Subject: RE: P/159/21/PL 253-255 Inglenook Hotel Pagham Road Pagham PO21 3QB

Simon J Davis MRTPI
Principal Planning Officer
Directorate of Place

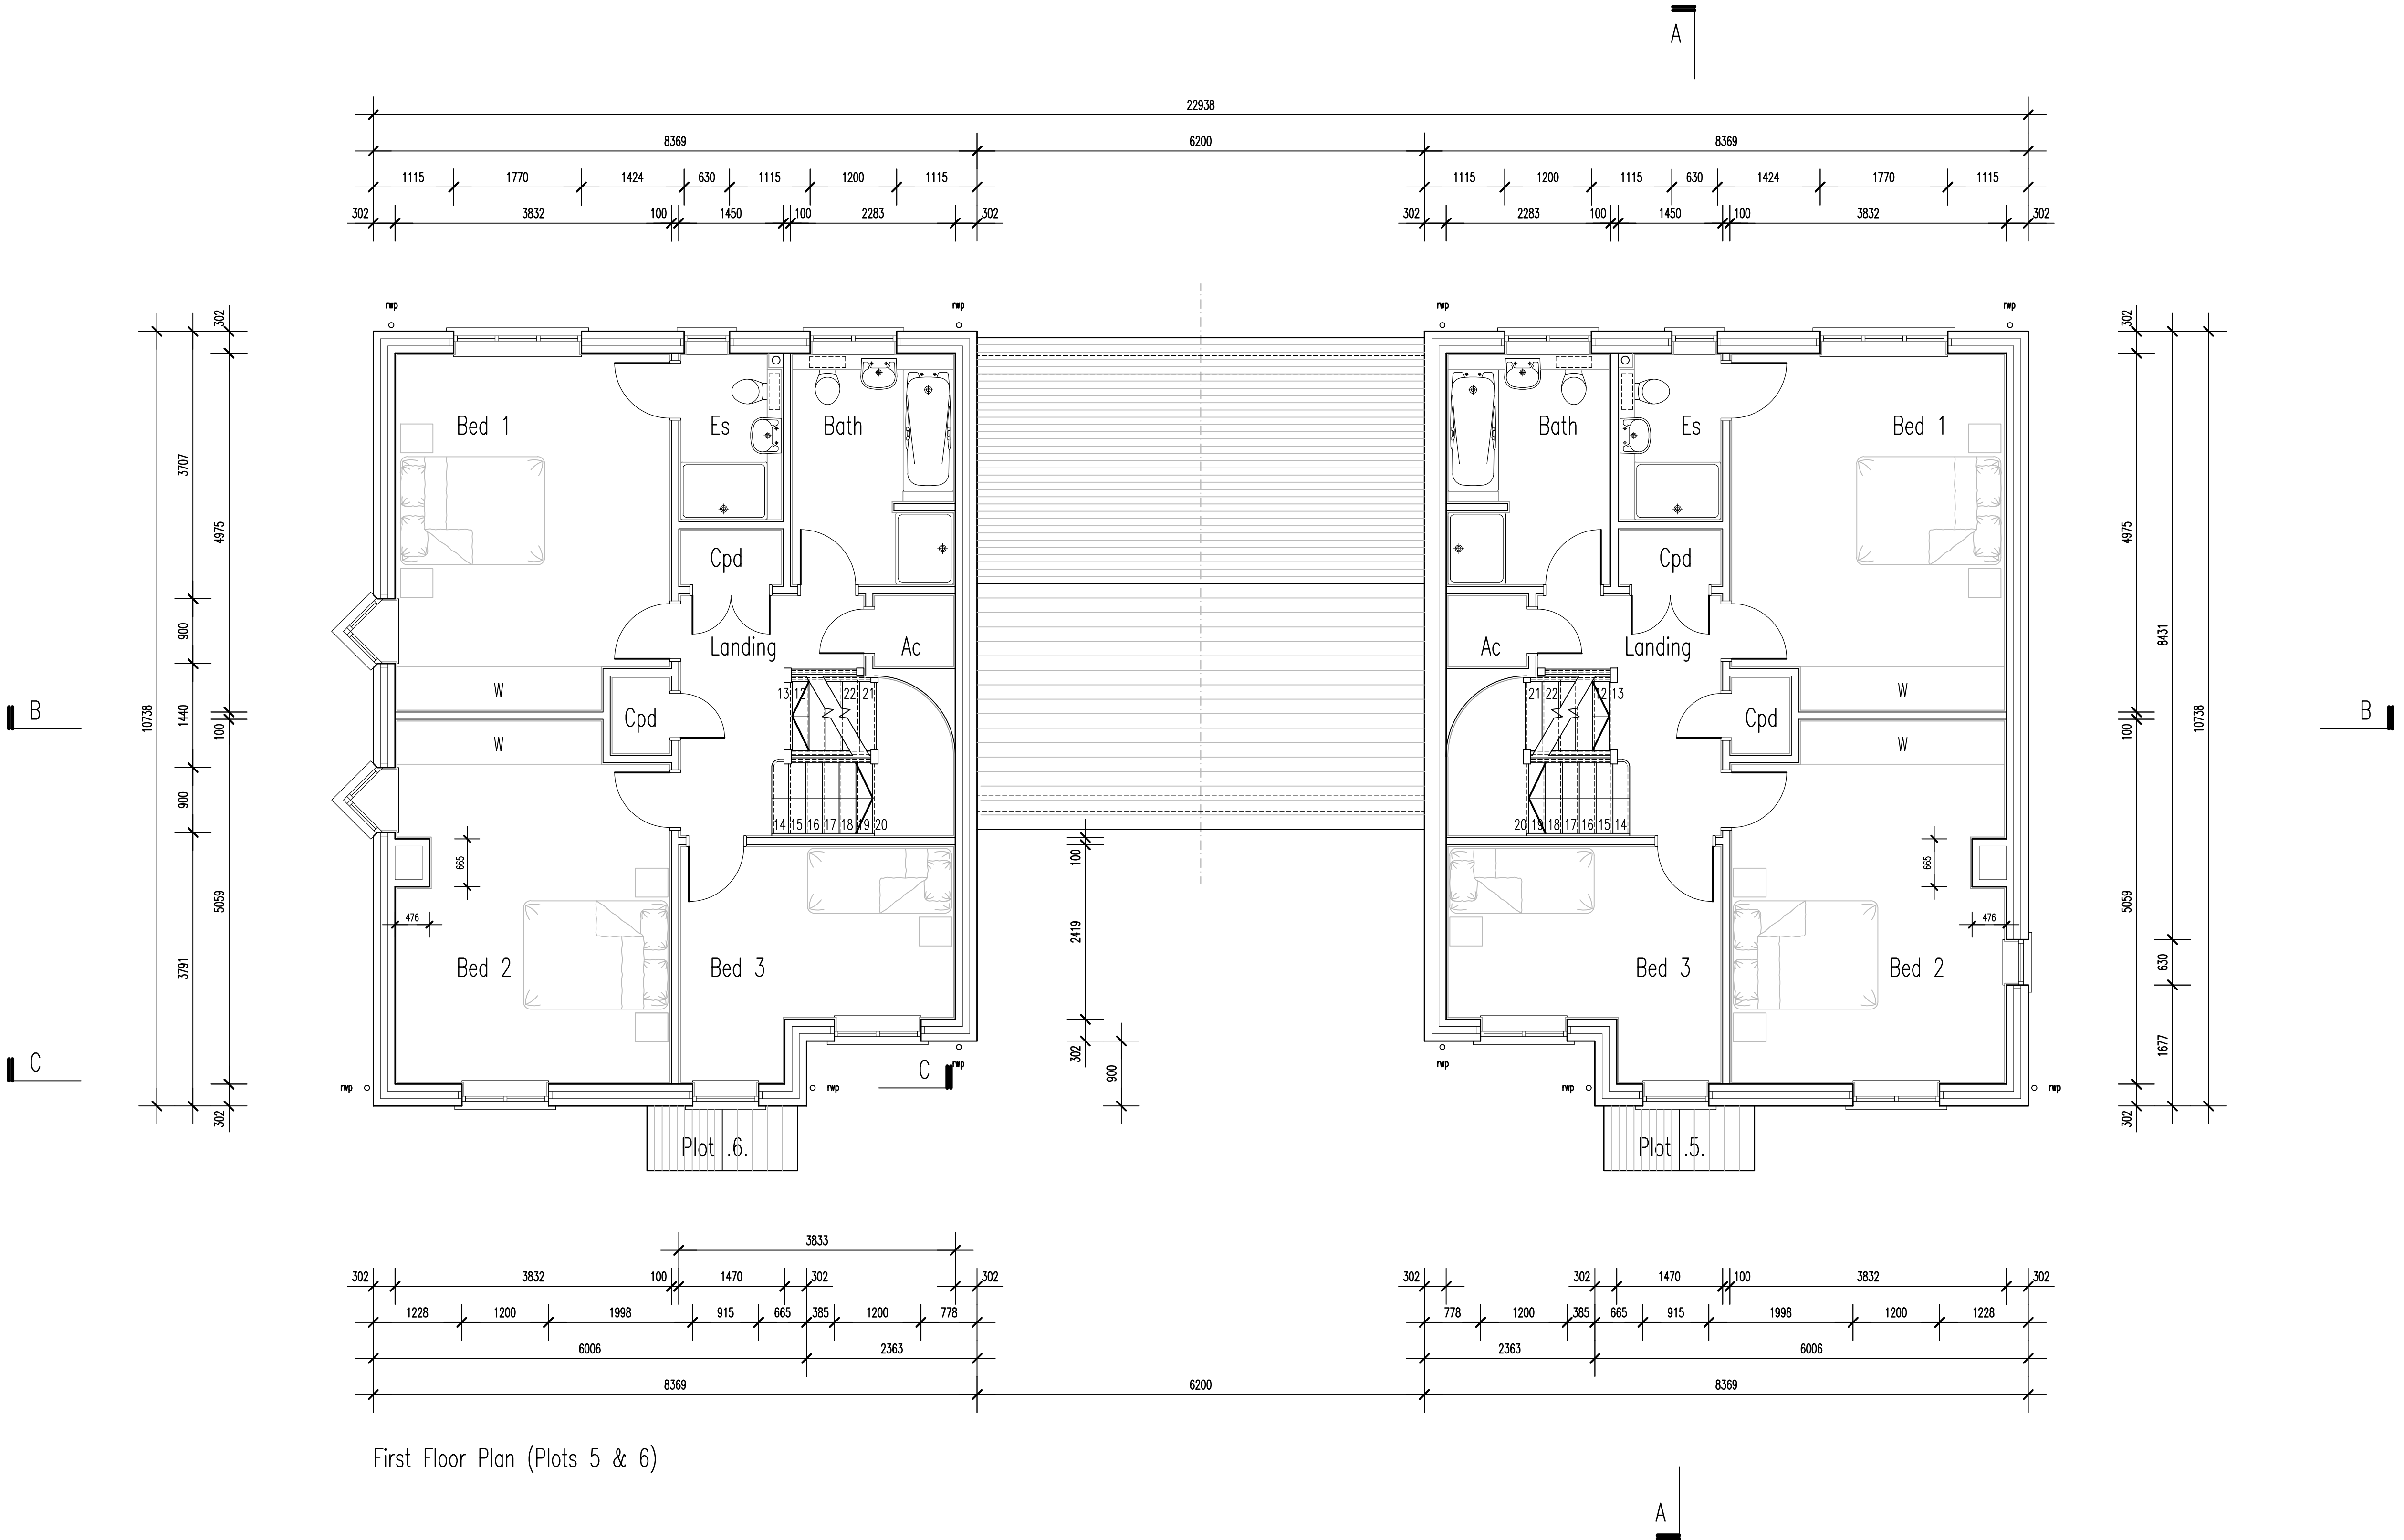
I acknowledge that the development has already been approved, that it is not appropriate to reassess the whole scheme and that the previous decision was pre the adoption of the Arun Parking Standards SPD. However, the addition of the 4th bedroom to plots 5, 6, 8, 9 adds a requirement for 1 extra space to each of these dwellings (so 4 in total) and so I have to therefore assess the extra requirements. You could resolve this be either removing the 2nd floor accommodation from the scheme, replacing the garages to these plots with car ports or finding 4 spaces elsewhere in the layout.
